re: **Site Servicing Plan Review**
Proposed Self Storage Development
75 Michael Cowpland Drive – Ottawa, Ontario

date: September 5, 2023

file: PG3798-MEMO.02 Revision 1

Site Servicing Plan Review

APPROVED BY:
 T.R.B.

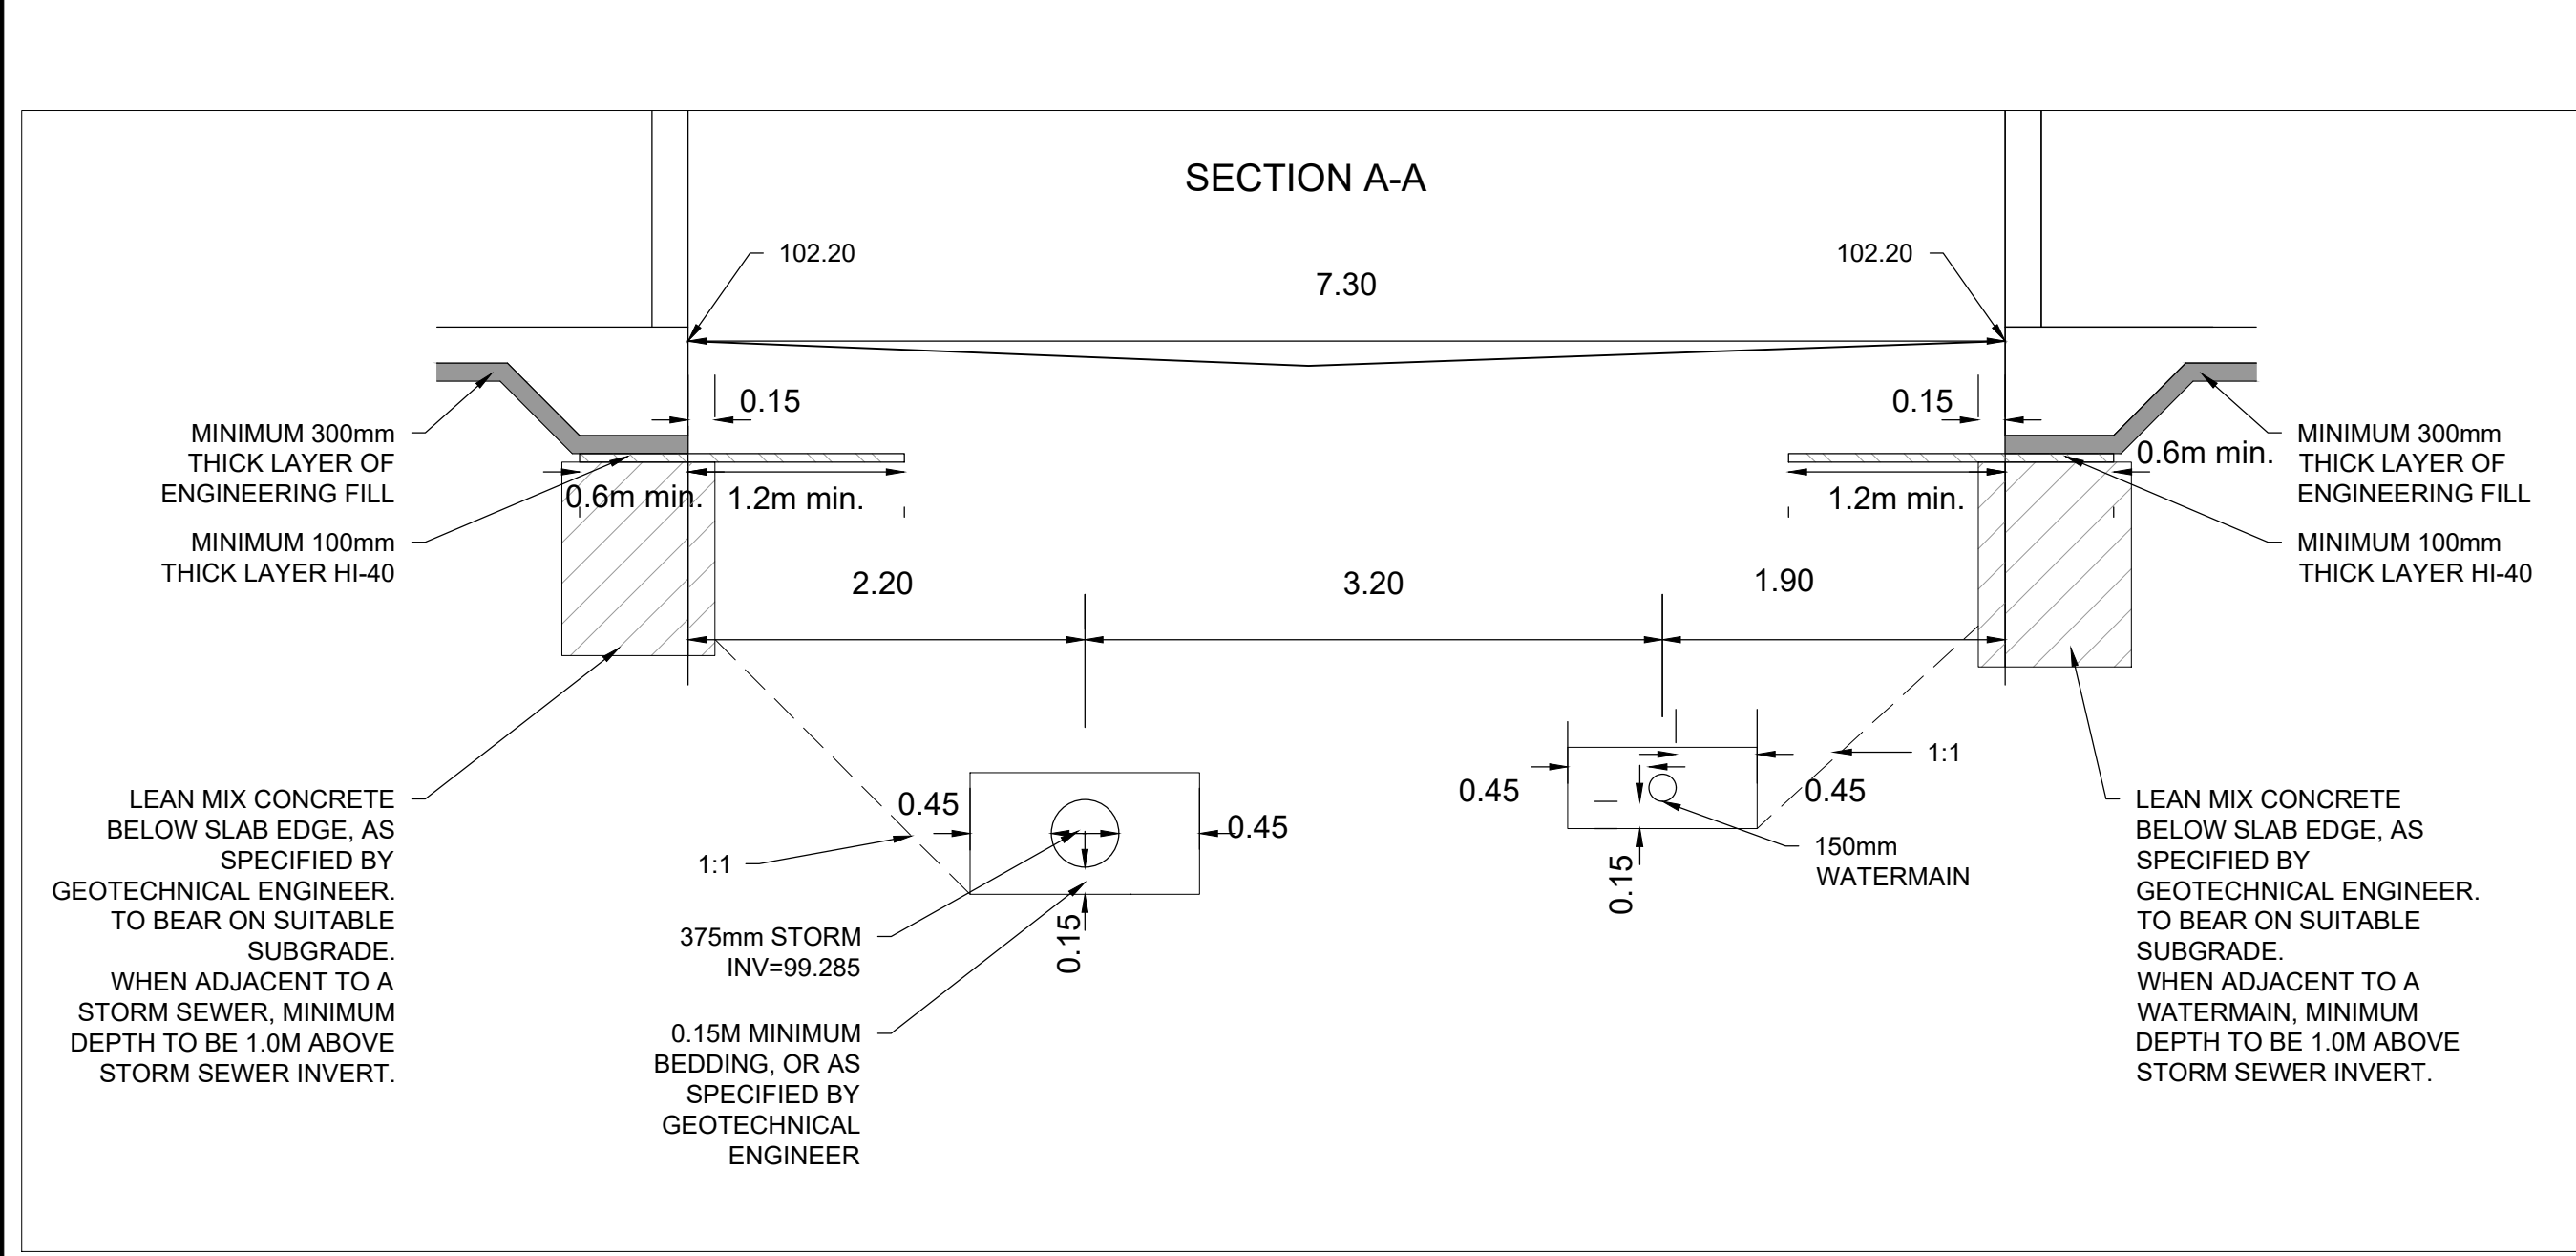
It should be noted that insufficient frost protection has been provided for several segments of the existing storm sewer services, mostly related to the pipes from catch basins tying into the main storm drain throughout the subject site. At these locations, the invert level of the storm sewer services are located within the frost zone (i.e. approximately 1.8 m below the proposed finished grade).

Due to the proposed grading and the addition of the proposed retaining wall, minimal frost cover is provided for the existing service alignments. Therefore, additional frost protection is recommended for these services.

It should be noted that the existing shallow services pipes along the north corner of the site will be subject to insulation due to the new proposed grading at the subject site. Depending on the soil cover above the invert level of the pipes, the following table indicates the minimum thickness of rigid insulation required to be placed directly above the obvert of the subject pipes. A minimum HI-40 rigid insulation panels should be placed directly above the existing pipes and should extend horizontally beyond the edges of the subject pipes as shown on *Figure 1 – Typical Rigid Insulation Detail* below.

It is recommended the near-vertical trenches extend a minimum of 150 mm horizontally beyond the overlying footing footprint. Based on our review, the lean-concrete trench detail has been incorporated satisfactorily into the above-noted site servicing plans with the exception of widening the trench a minimum of 150 mm beyond the face of the overlying thickened edge footing footprint.

Where the lean-concrete trenches will terminate within the frost zone for a heated building, it is recommended to extend a minimum 100 mm thick layer of HI-40 rigid insulation a minimum horizontal distance of 900 mm beyond the overlying building footprint. The location of this insulation is depicted in blue on *Figure 1 – Thickened Edge Slab Insulation Details and Plan* attached to this memorandum. Where the lean-concrete trench is anticipated to extend below frost zone for a heated building, the exterior building insulation has been omitted from the above-noted plan.

Table 1 - Rigid Insulation Recommendations for Storm Sewer Pipes with Reduced Soil Cover			
Thermal Condition	Soil Cover Provided (mm)	Insulation Dimensions	
		Thickness (mm)	Extension (mm)
Unheated	600 to 900	125	Extend 1200 mm horizontally beyond edge face of the sewer
	900 to 1200	100	Extend 1200 mm horizontally beyond edge face of the sewer
	1200 to 1500	75	Extend 900 mm horizontally beyond edge face of the sewer
	1500 to 1800	50	Extend 600 mm horizontally beyond edge face of the sewer
	1800 to <2100	25	Extend 300 mm horizontally beyond edge face of the sewer

All rigid insulation should consist of either Dow Chemical High-Load 40 (HI-40) or equivalent other approved by Paterson. The placement of all insulation within the service trenches must be reviewed and approved by Paterson personnel at the time of construction.
